MMO Reference: DCO/2022/00003
Planning Inspectorate Reference: EN010136
Identification Number: 20048964

Planning Act 2008, BP Alternative Energy Investments Ltd, Proposed Morgan Offshore Windfarm Generation Assets Order

Deadline 4

This document comprises the MMO's submission for Deadline 4.

Figure 1.3: Indicative location of Scallop Mitigation Zone.

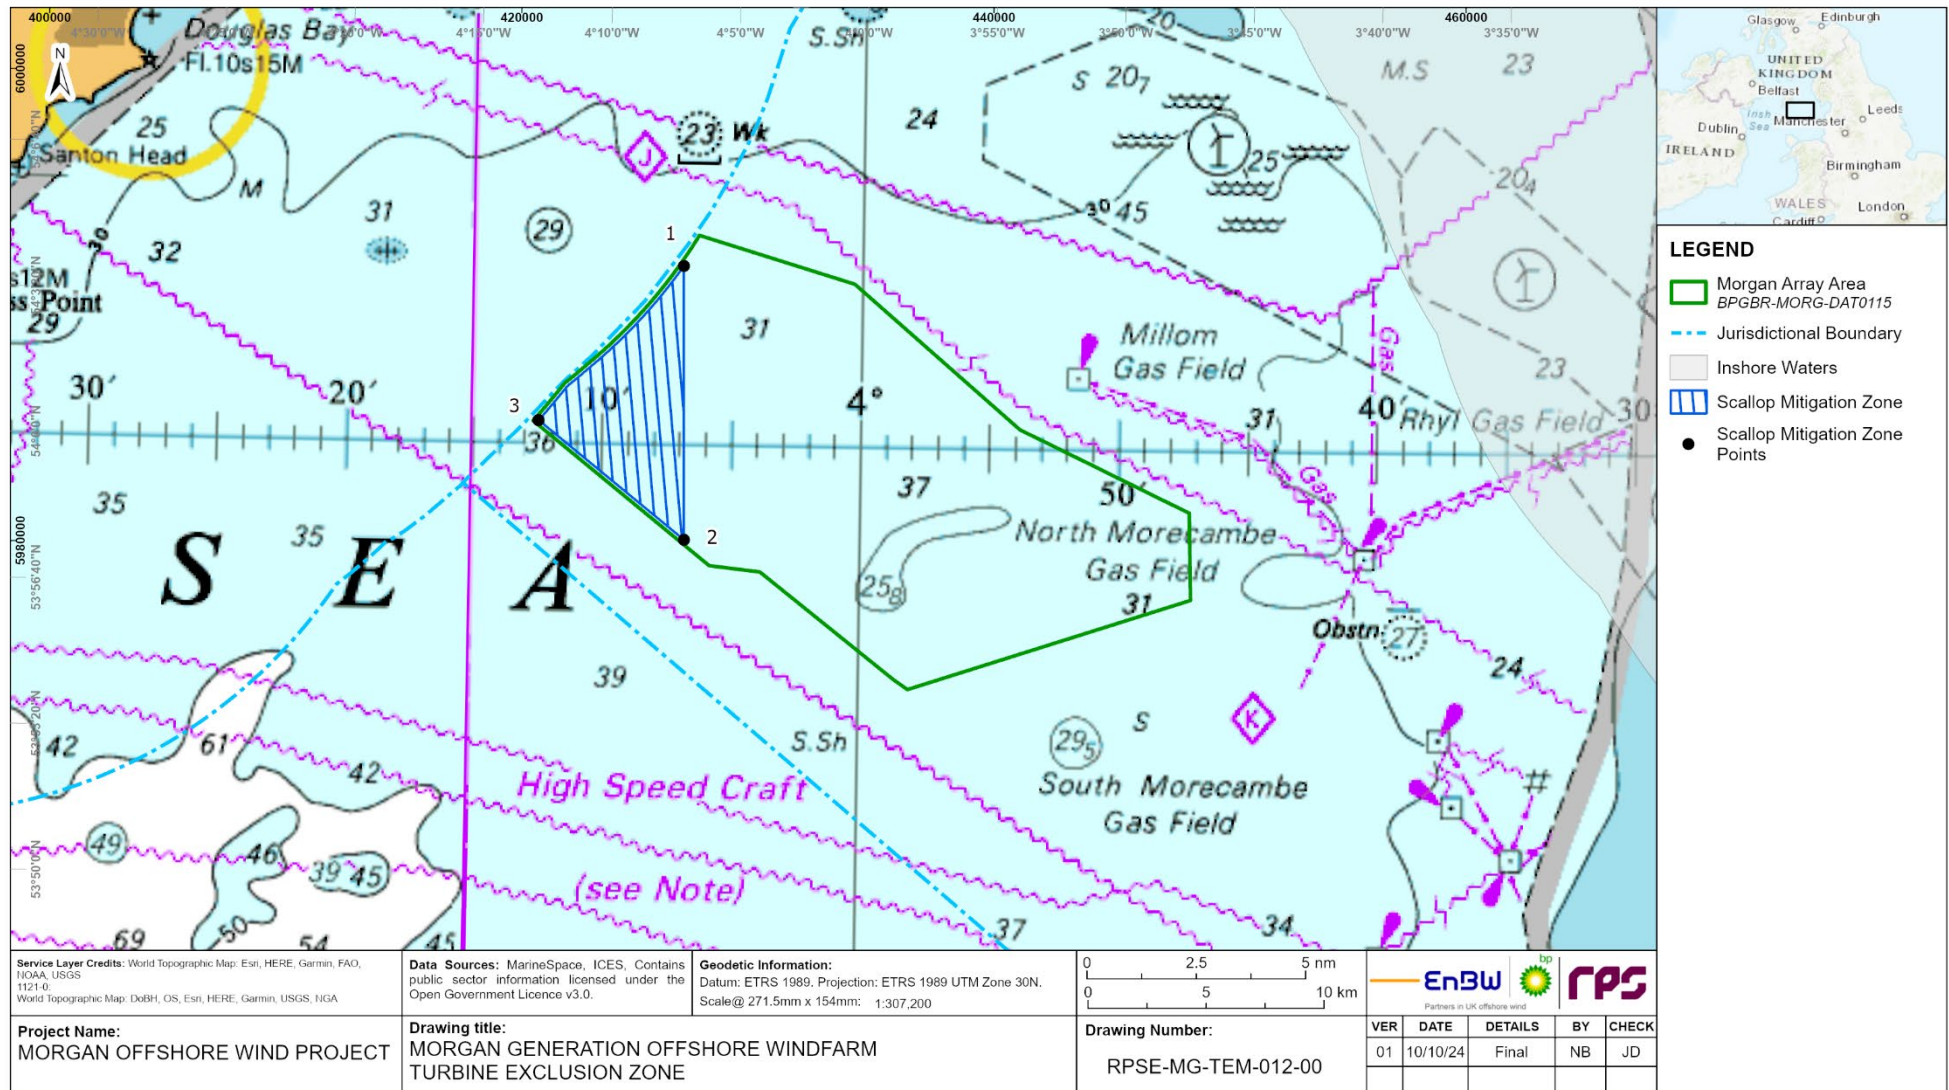
| | <p>Zone (SMZ) is secured only through the outline FLCP, such that it would only effectively be secured under the condition to develop an offshore EMP.</p> <p>ii) The proposed SMZ is not referenced on the Works Plan [APP-082] whereas the outline fisheries liaison and co-existence plan (FLCP) [REP2-019] illustrates an “indicative SMZ”. Should the Works Plan be amended to show the “indicative” SMZ and should co-ordinates for the SMZ be included in the draft DCO/DMLs?</p> | <p><i>“2.—(1) The wind turbine generators to be constructed as part of the authorised development must be located within the area shown on the works plan.”</i></p> <p>The works plan will be a certified document under schedule 5 of the draft DCO. It is not appropriate to include an ‘indicative’ area on a document that controls how the Proposed Development could be constructed, as until the area is fixed it could be changed.</p> <p>The Applicant considers that the inclusion of the SMZ within the fisheries liaison and co-existence plan (FLCP) is appropriate. That plan will be approved by the MMO in accordance with condition 20(1)(e)(v) of each dML. Condition 21(3) of the dML provides:</p> <p><i>“The licensed activities must be carried out in accordance with the plans, protocols, statements, schemes and details approved under condition 20, unless otherwise agreed in writing by MMO.”</i></p> <p>The final SMZ included in the FLCP will therefore require to be adhered to by the Applicant, and the SMZ can be enforced by the MMO.</p> | <p>any plan and its contents is enforceable and would be approved by the MMO in consultation with interested parties prior to the start of construction.</p> <p>The MMO has concerns on the SMZ only being indicative at this stage and any outstanding comments from Interested parties. If the SMZ is finalised a standalone outline plan could be beneficial.</p> <p>The MMO notes that the Applicant states that the inclusion of the SMZ within the fisheries liaison and co-existence plan (FLCP) is appropriate.</p> <p>In addition to this the MMO notes a scallop mitigation zone has not been standard in many offshore wind projects and is reviewing the requirement and how this would be processed, should the final area not be agreed at this stage. The MMO believes that the zone should be agreed during the determination process. The MMO will provide an update in due course.</p> |
